## **Response to Submissions**

State Significant Development  
Application SSD-81300458

Residential Flat Buildings  
85-91 Thomas Street, Parramatta

17 October 2025

PROJECT TITLE:
**PROPOSED RESIDENTIAL APARTMENTS
85 TO 91 THOMAS STREET,
PARRAMATTA**
DRAWING TITLE:
LOWER GROUND FLOOR PLAN

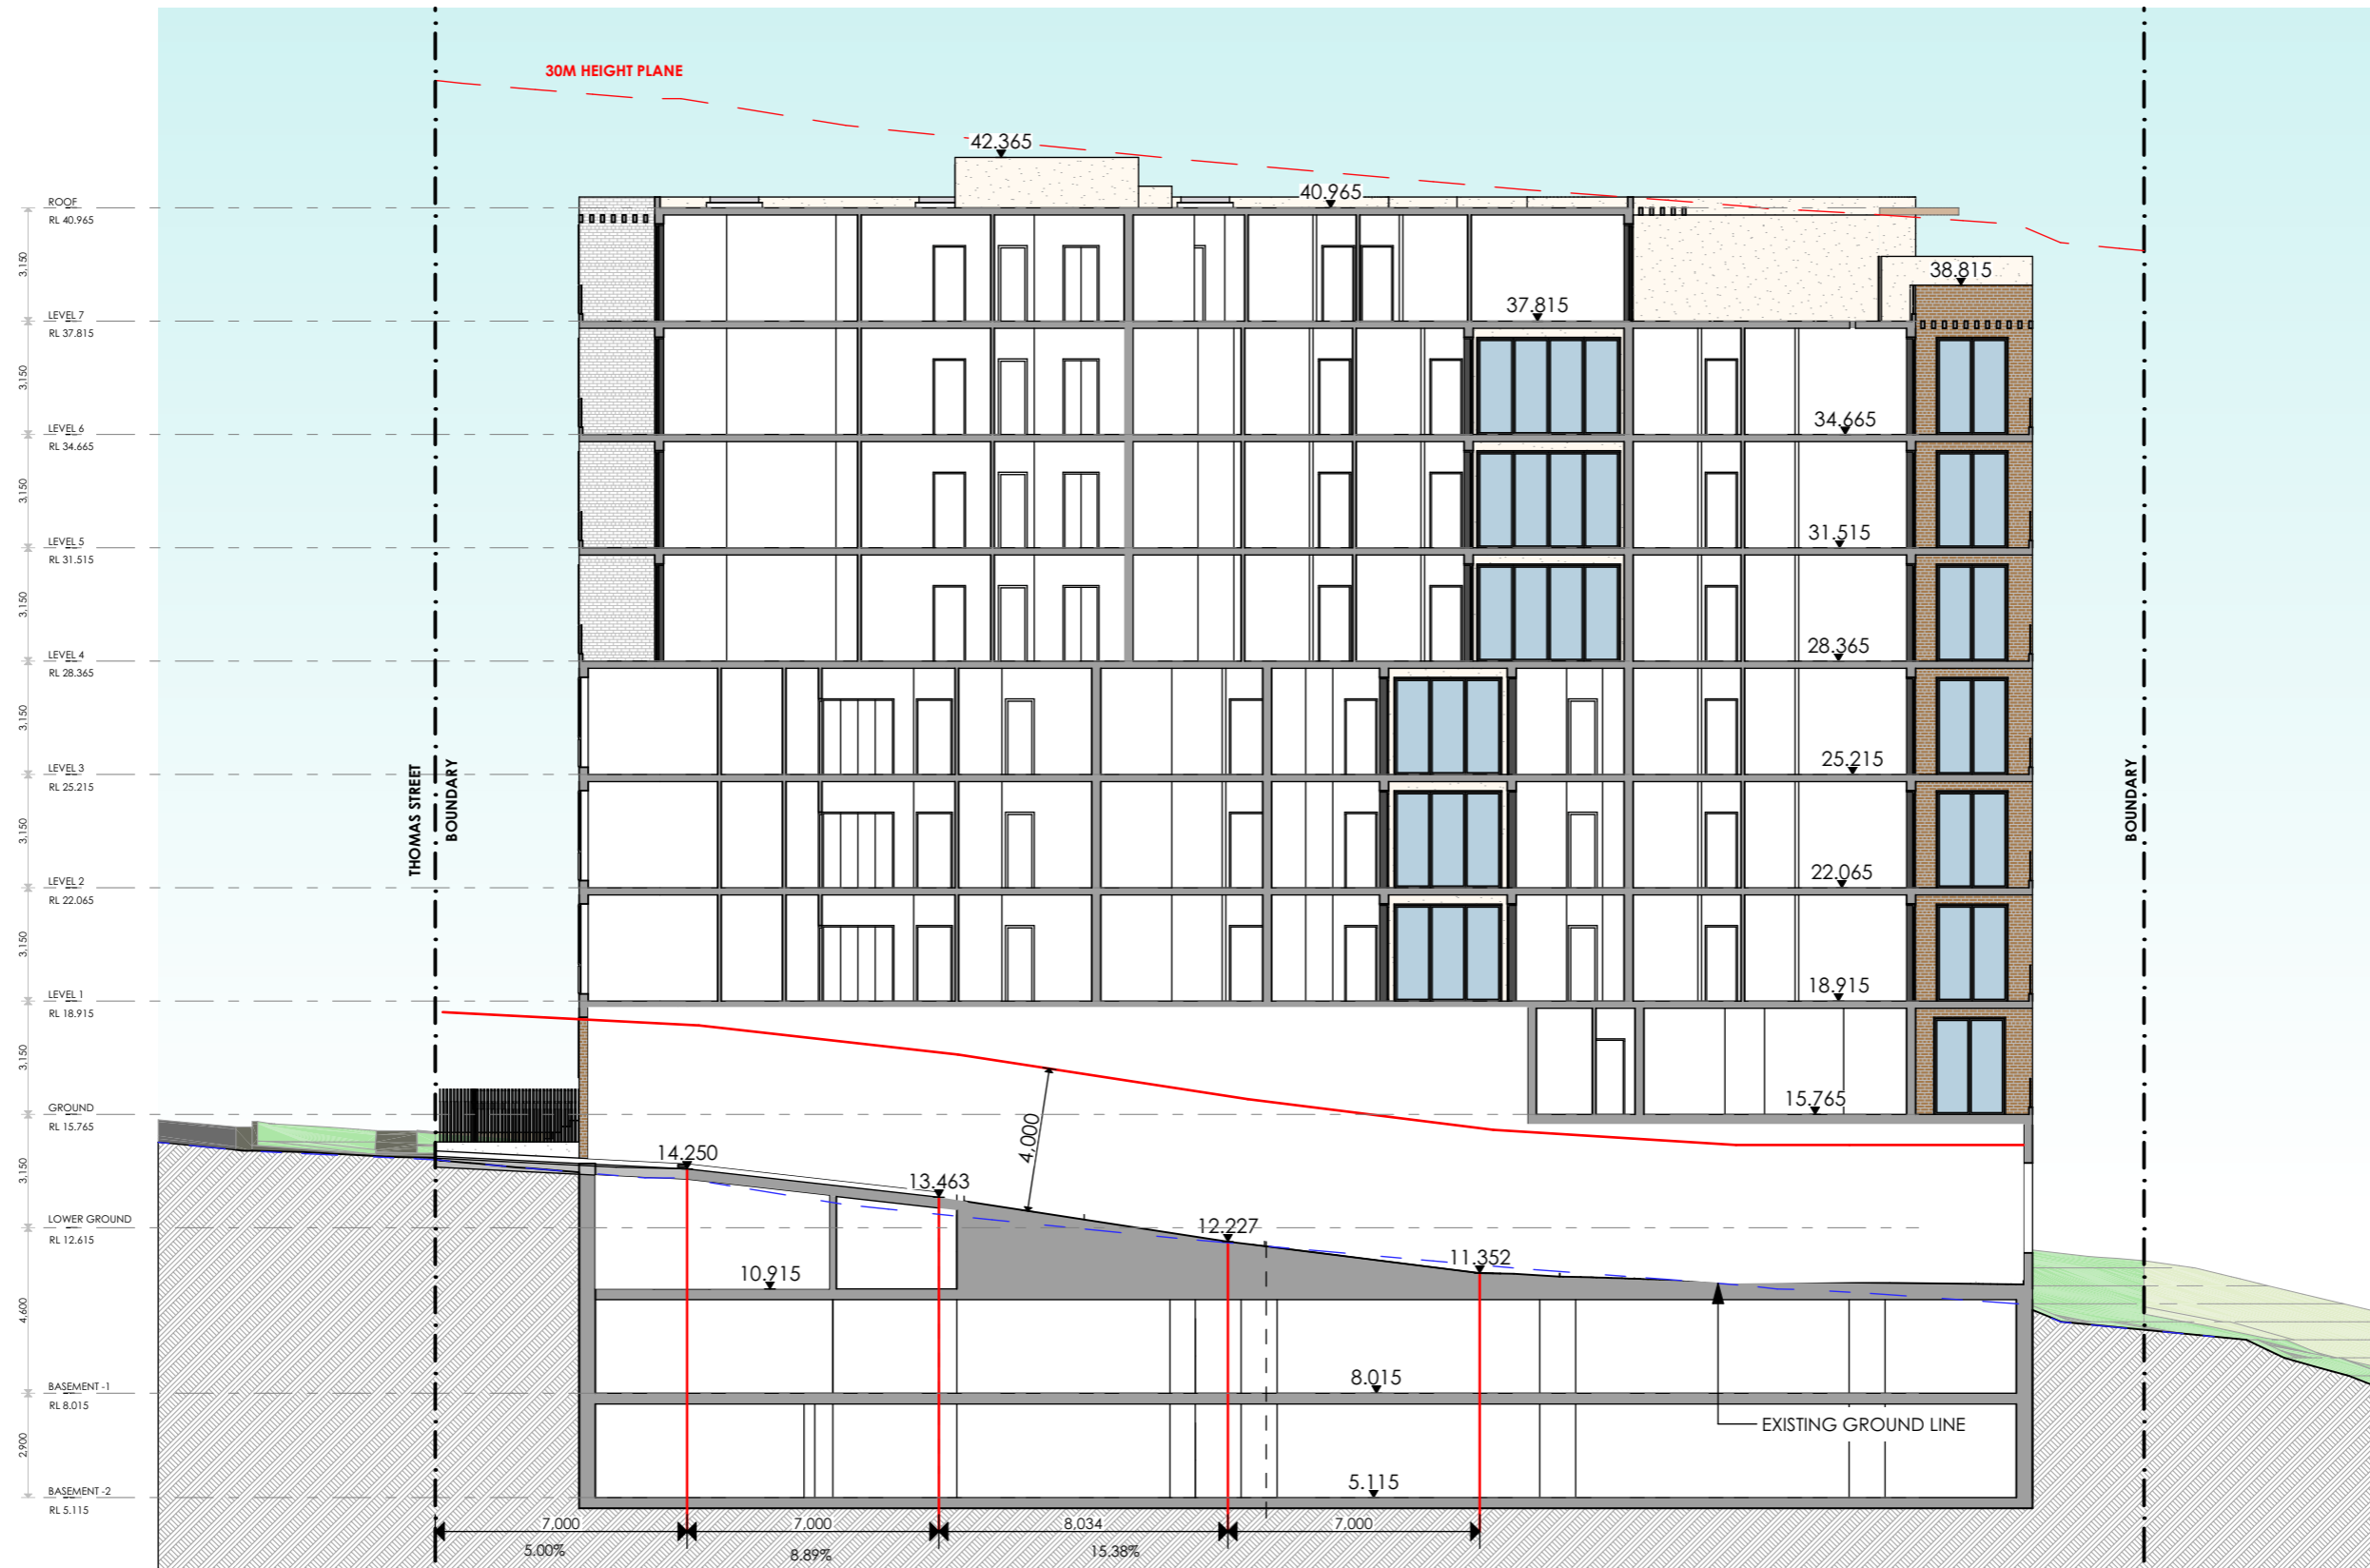
*Issue:* DPHI queried whether the amenity of the proposal’s internal open space was suitable as there was an assumption that such space was not provided with natural light.

*Response:* Whilst the internal CoS is within the lower ground, over head sky lights were included to enable natural light entry, as shown in the following extract of the architectural plans.

Figure 1: Extract of lower ground and ground floor plan with skylight to internal CoS shown with yellow arrow (Source: PTI/PPUD)
